Drafted 22 June 2012

**Planning Applications, Ribble Valley District
3/12/0474 Vicarage Farm, Old Back Lane, Wiswell**

DIAGRAM OF PROPOSED GATE DESIGN  
HOCKEY-STYLE AND MIRRORS EXISTING  
GATE TO VICARAGE BARN COTTAGE

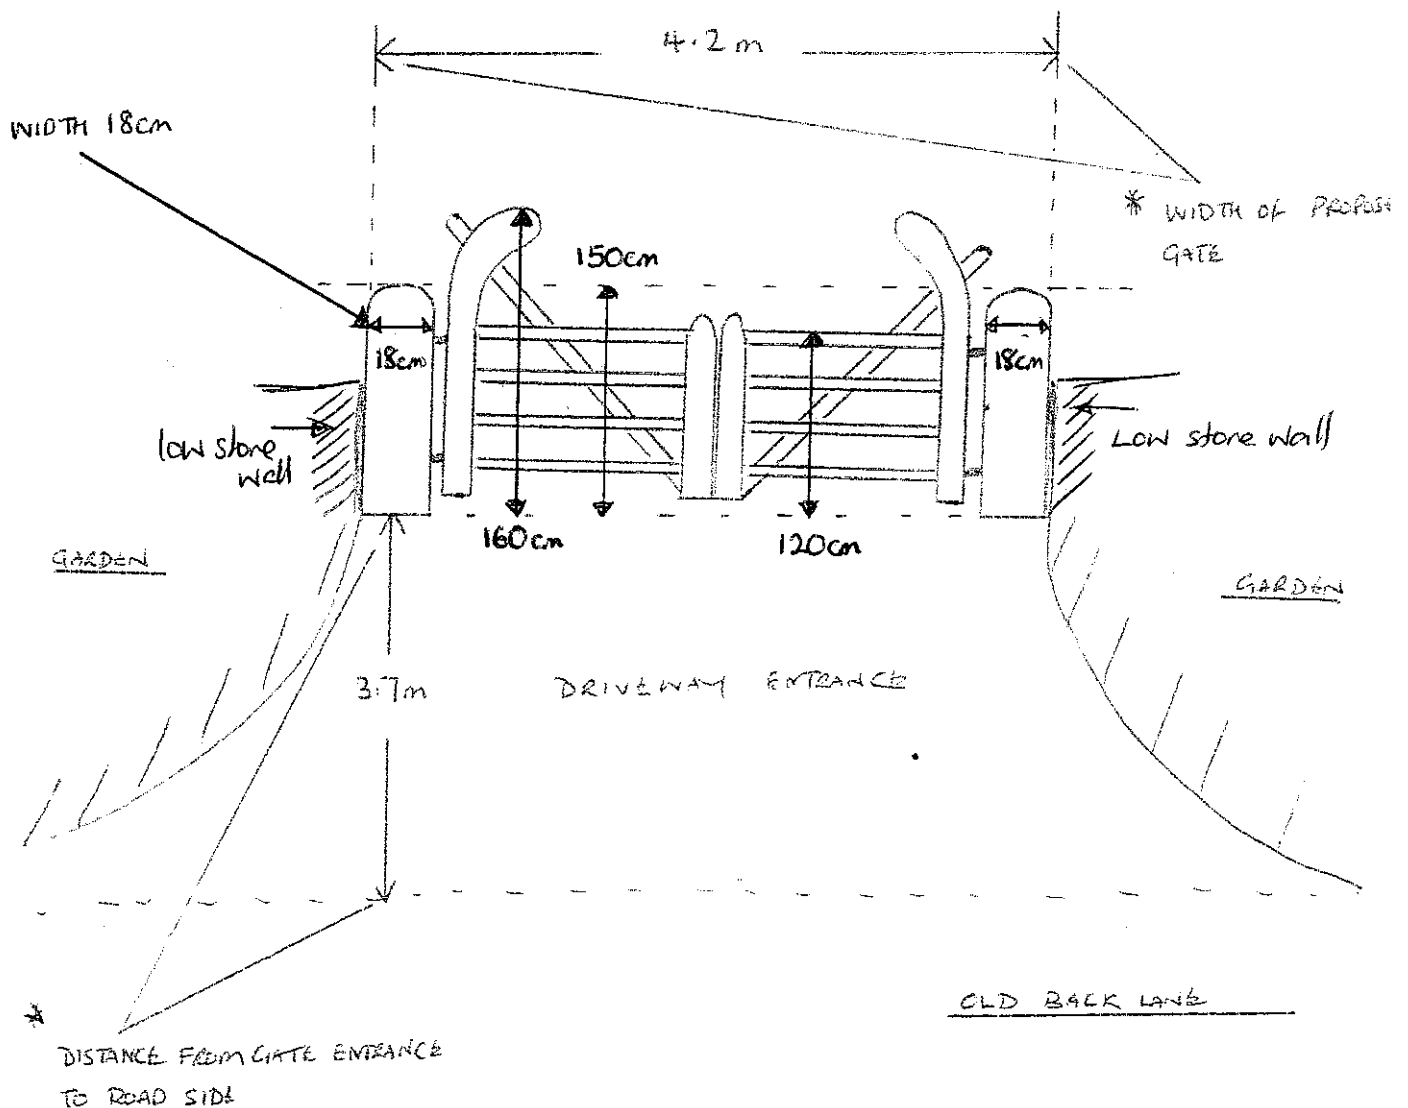
The proposed gate is set back 3.7m from the back of the carriageway. While this distance is below the 5.0m standard, it allows adequate off street parking provisions to be maintained at this property and secures an access arrangement that is sympathetic with the highway characteristics of Old Back Lane.
